Your ref:
Our ref: 23/02214/F
Please ask for: Lynn-Marie Elliott
Direct dial:
E-mail: borough.planning@west-norfolk.gov.uk

Details: **Single storey garden room extension to rear of bungalow to replace conservatory. at 21A Lamsey Lane Heacham King's Lynn Norfolk PE31 7LA**

Drawing no.
BRIT PL 1.1

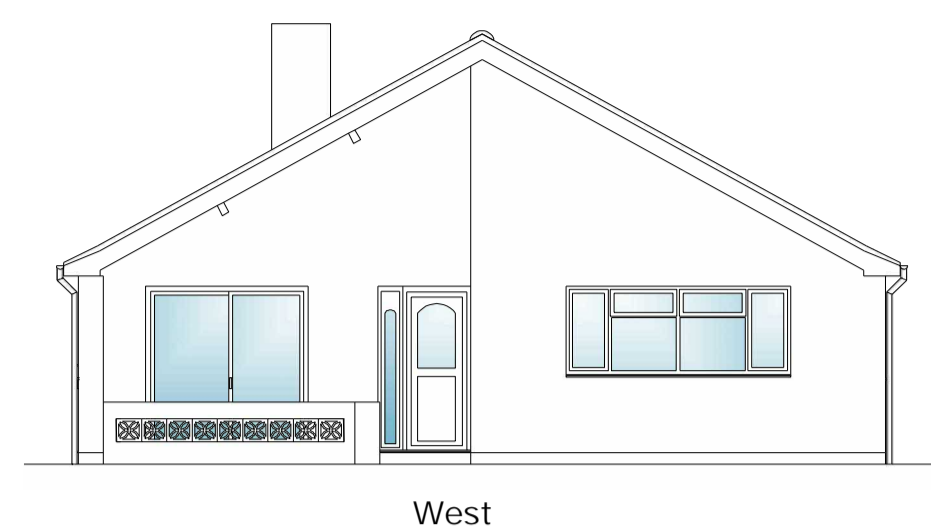
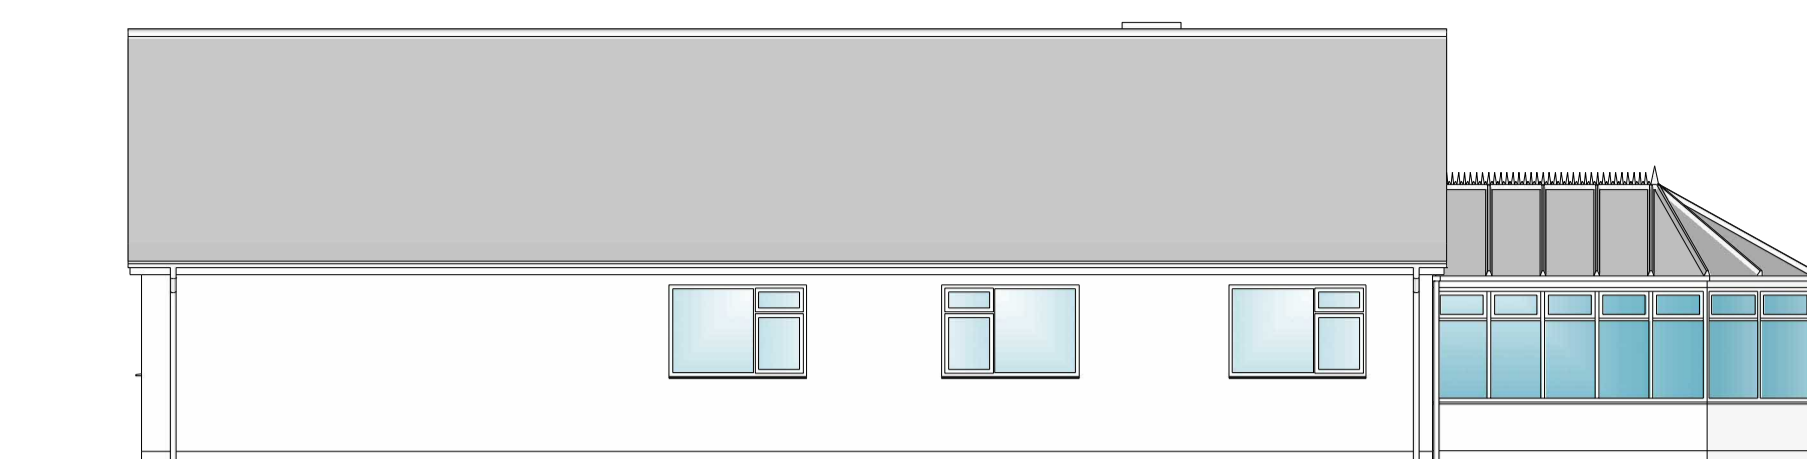
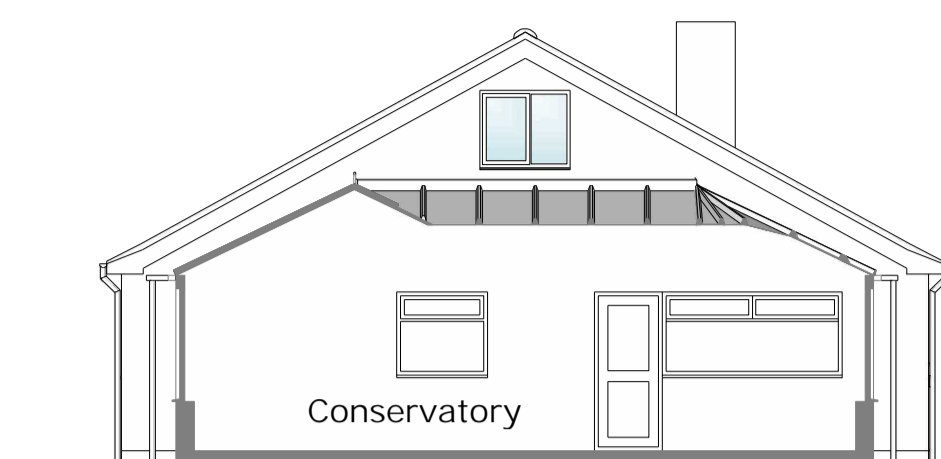
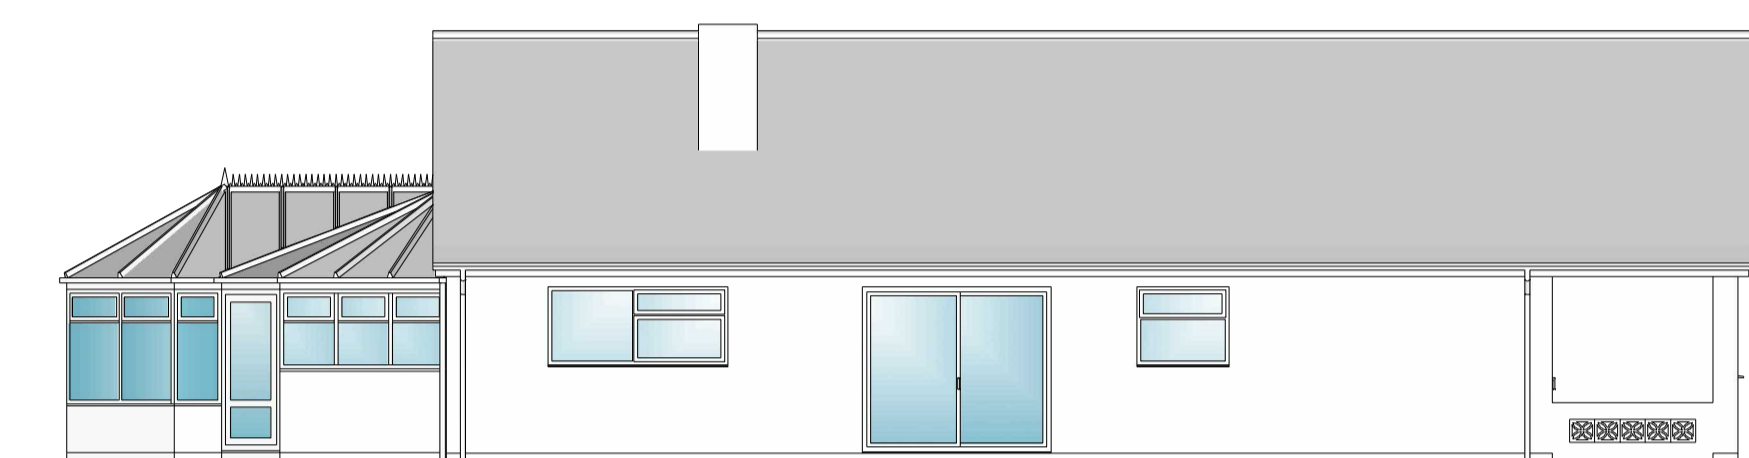
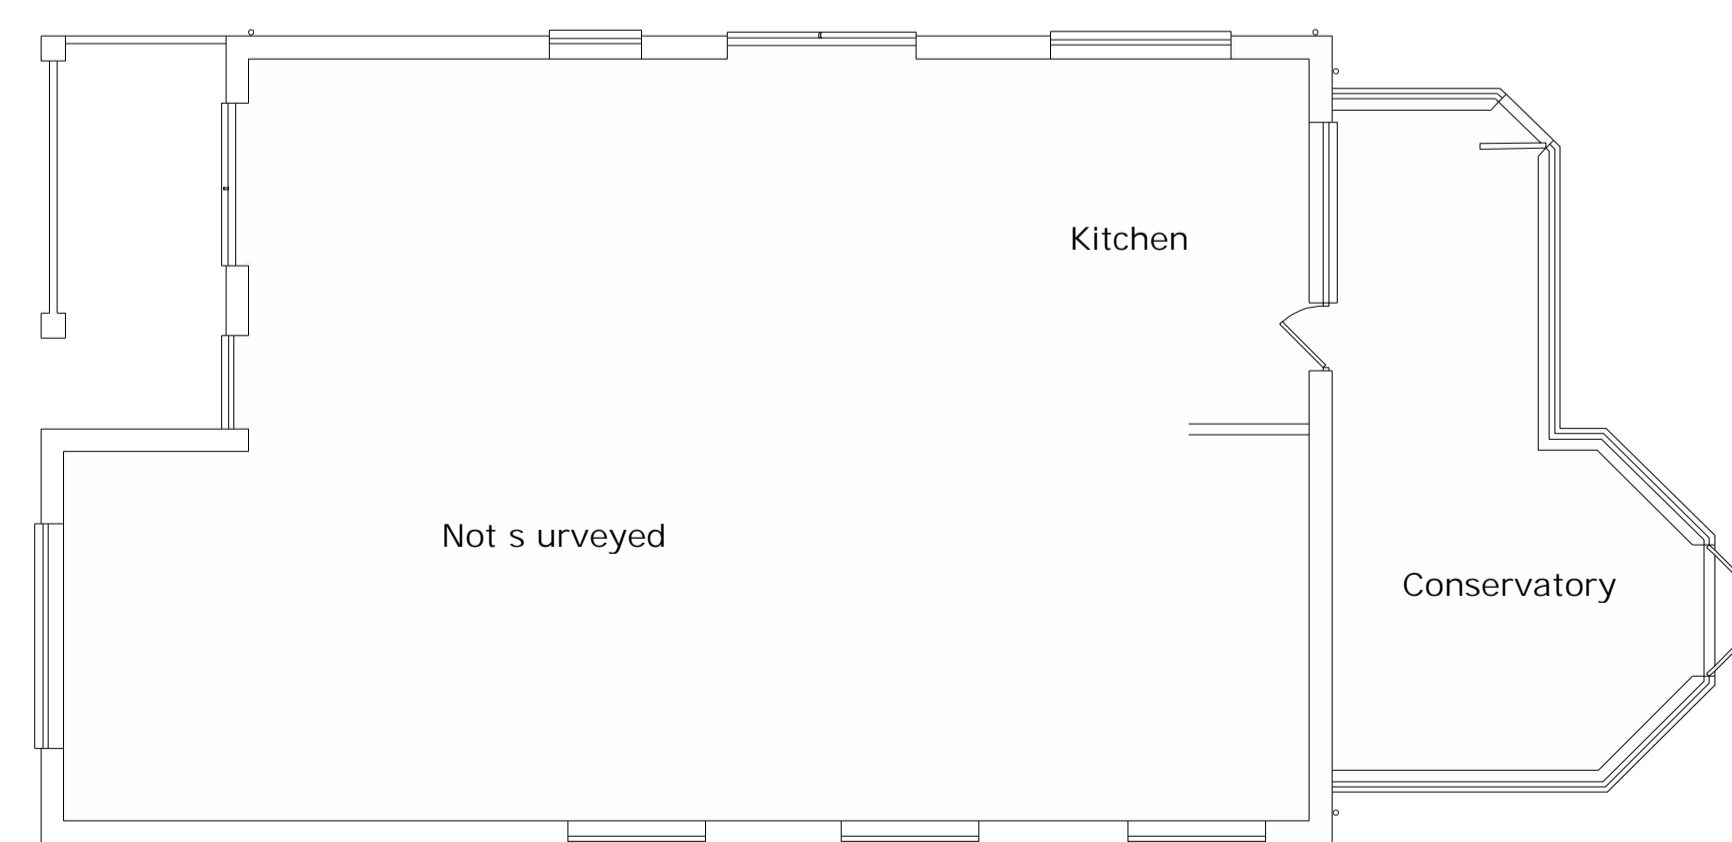
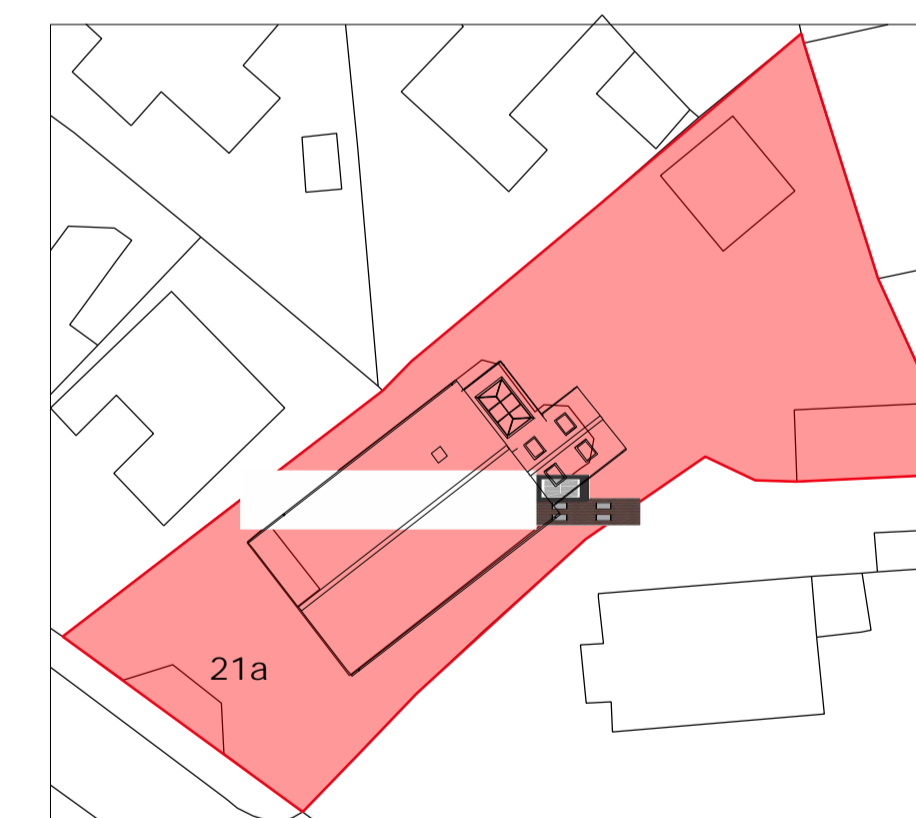
1. The annotation on the drawing(s) submitted with your application refers to the drawing being not to scale. Please remove any such reference for the purposes of the planning application.
